Application for a non-material amendment following a grant of planning permission.  
Town and Country Planning Act 1990

Demolition of small side extension.  
Construction of extensions on front and side elevations and internal elevations

DM/2020/00645

Reduction in the width of the side extension  
front door and screen to be recessed to form storm porch

Drawn	Date	CAD Ref.	Scale
MJC	23/02/20	C:\CAD\1519\1519-2B	1:50 & 1:100 @ A1
Checked	Date	Drawing No.	
		1519-2B

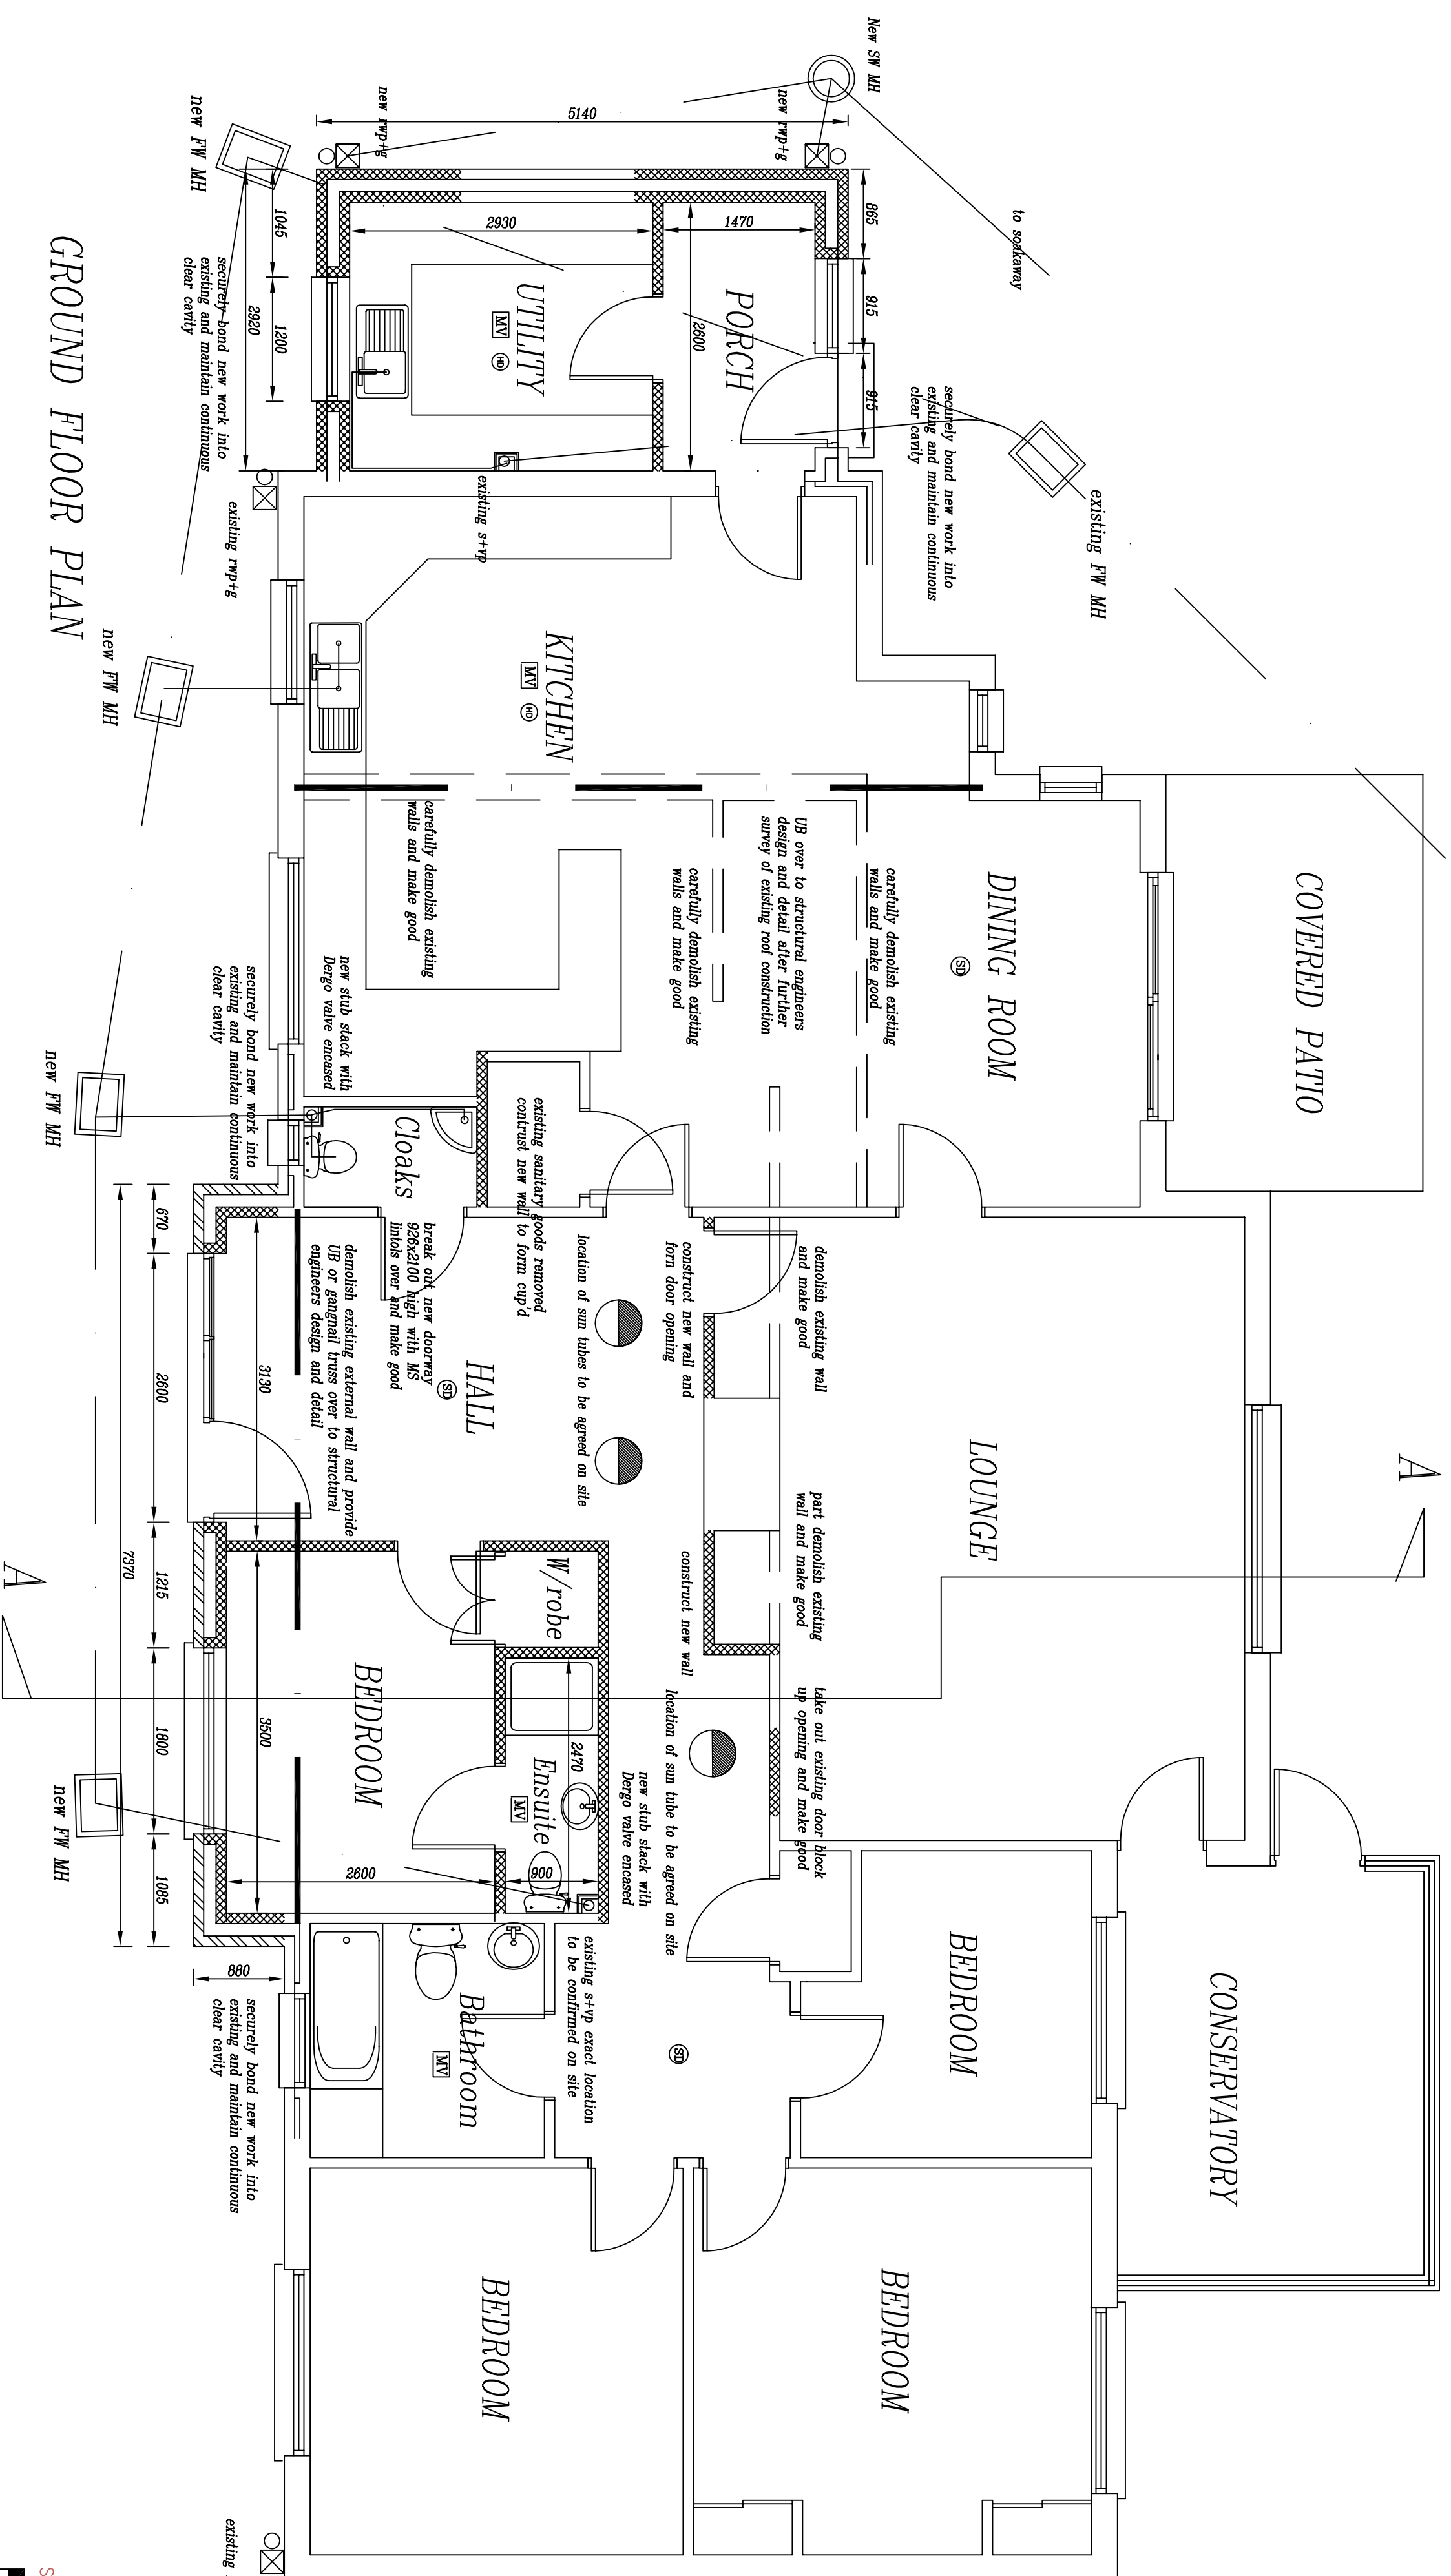
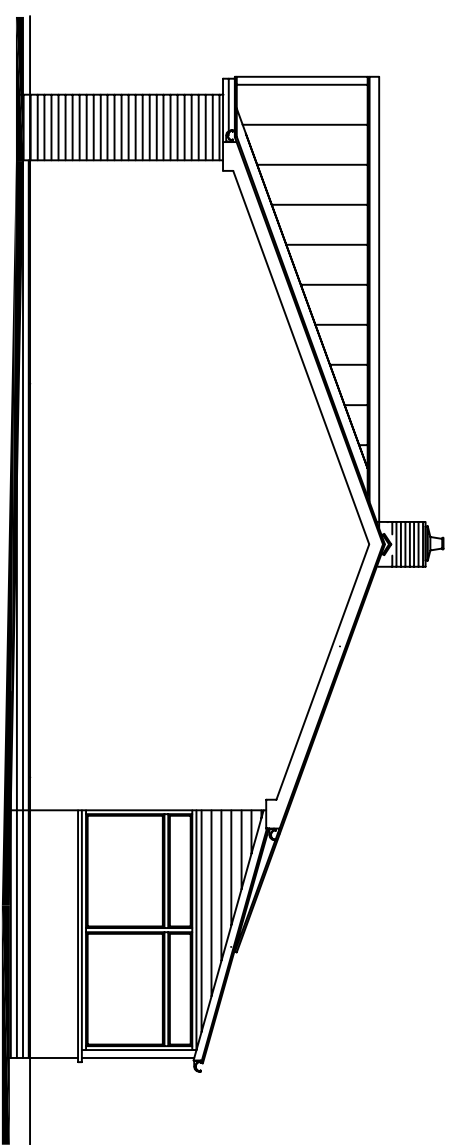
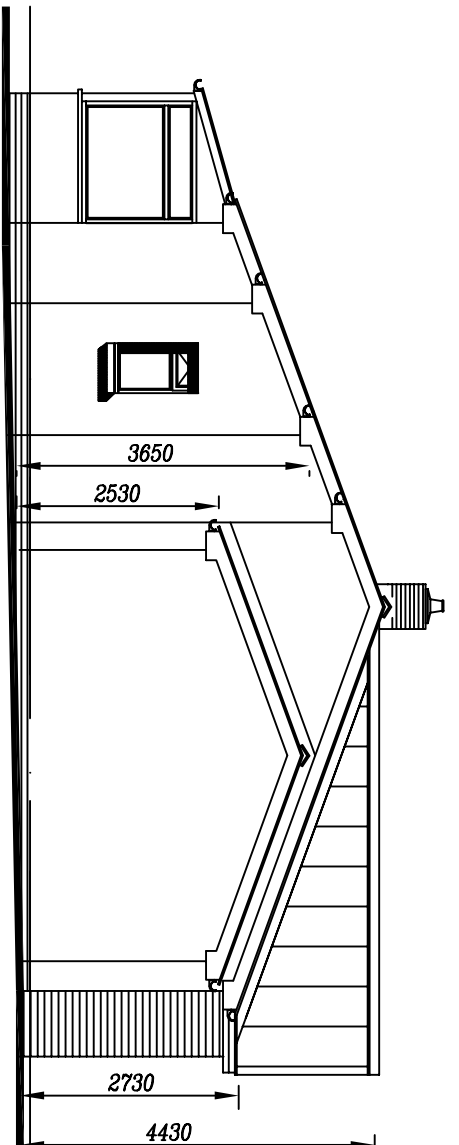
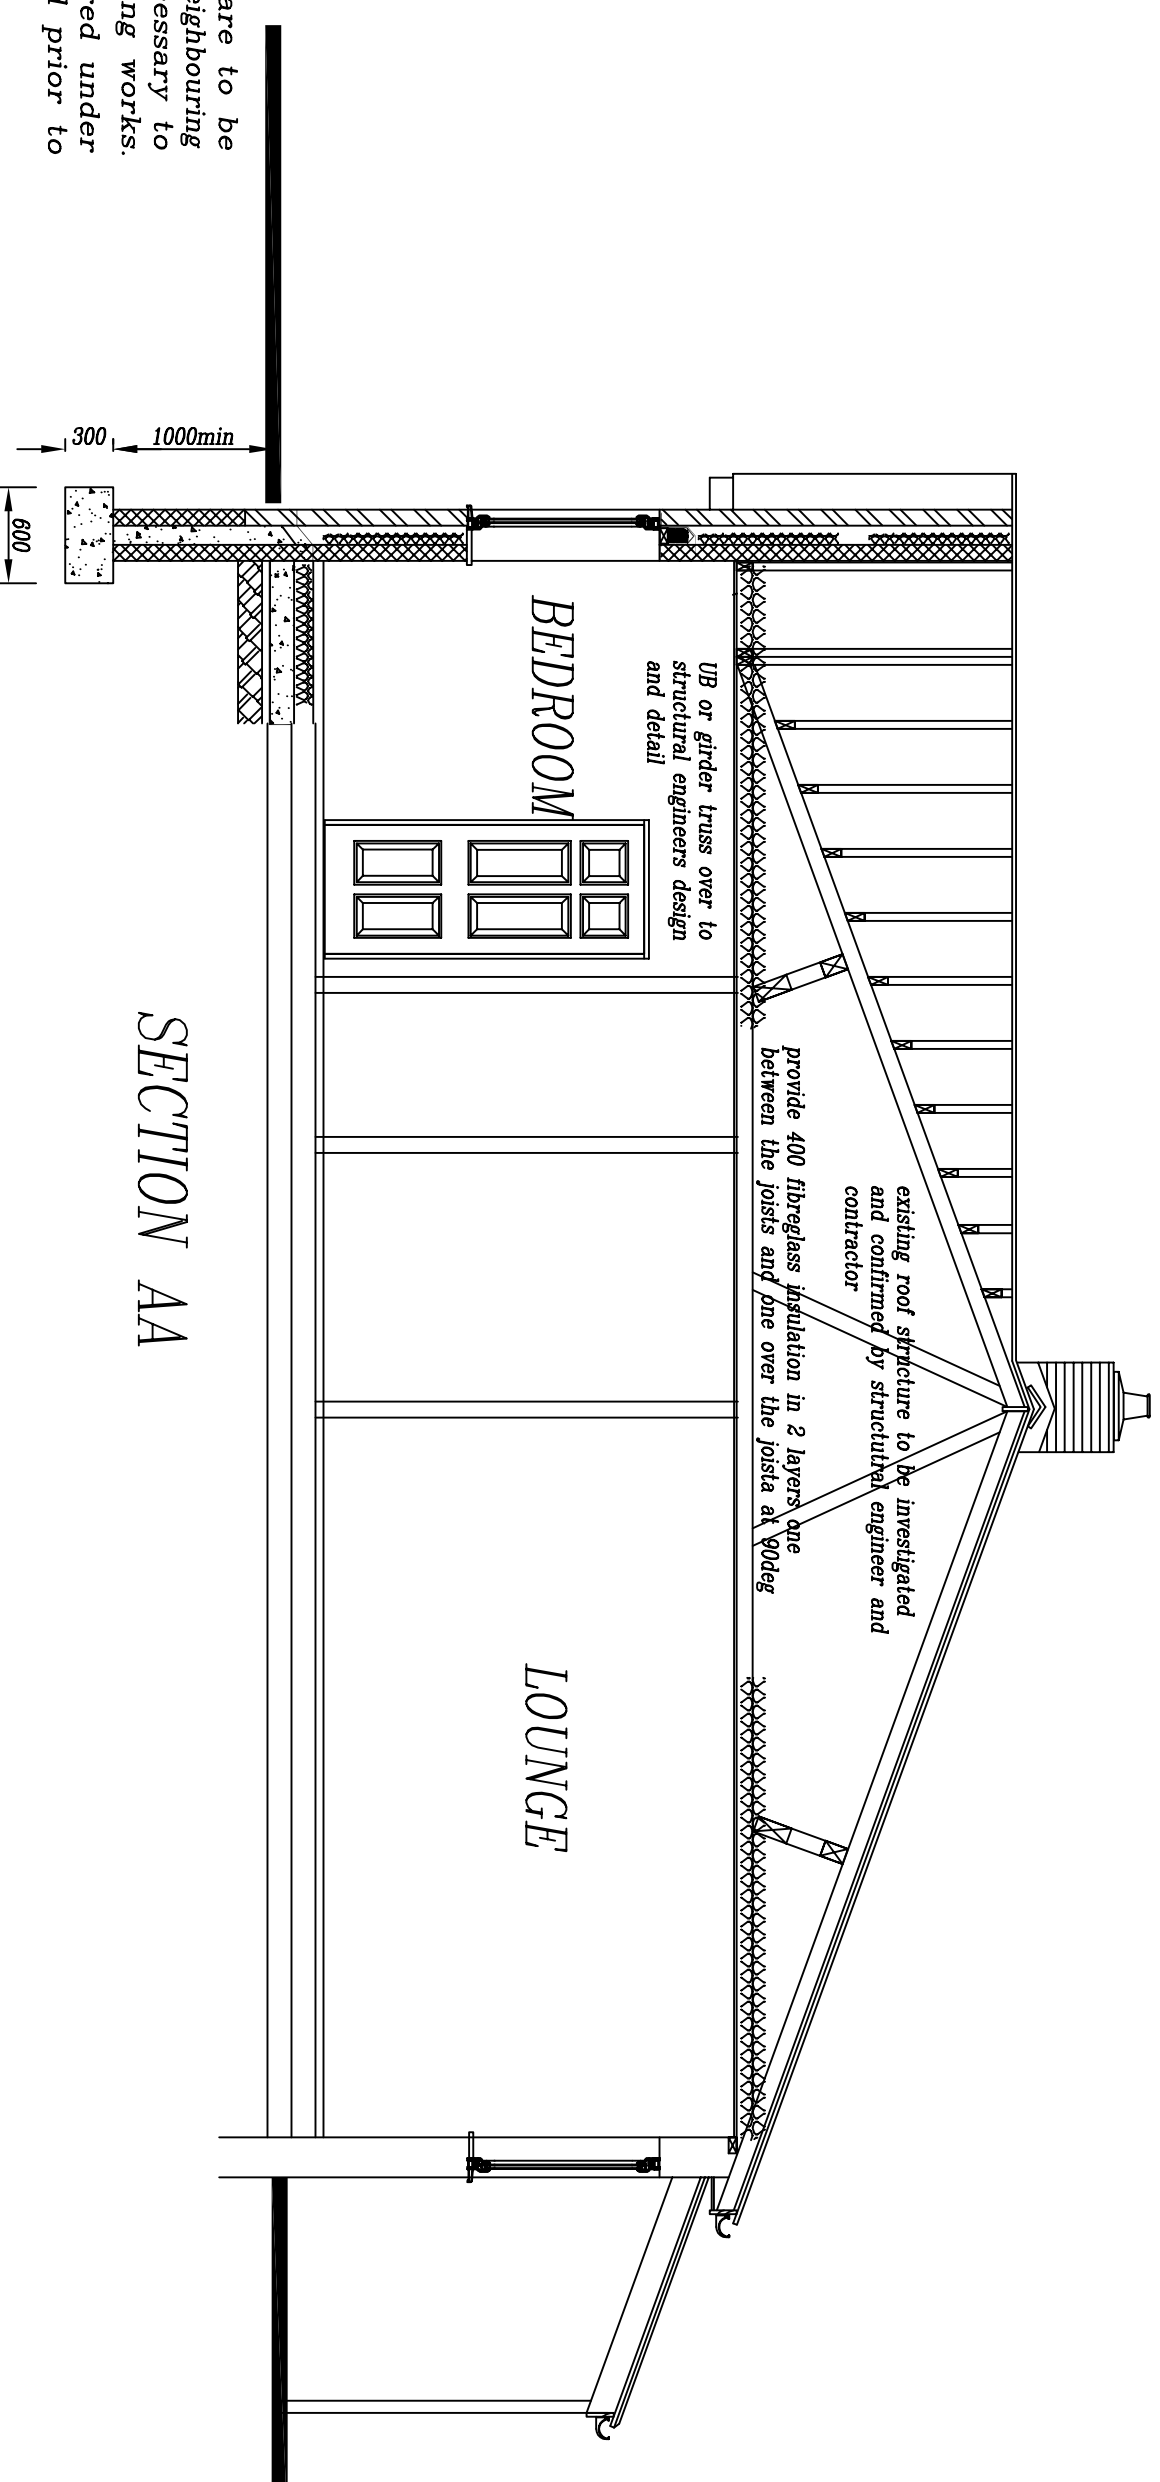
To form a storm porch at the front door and provide additional width to side boundary

1519/1, 2E & 5B (site location plan)
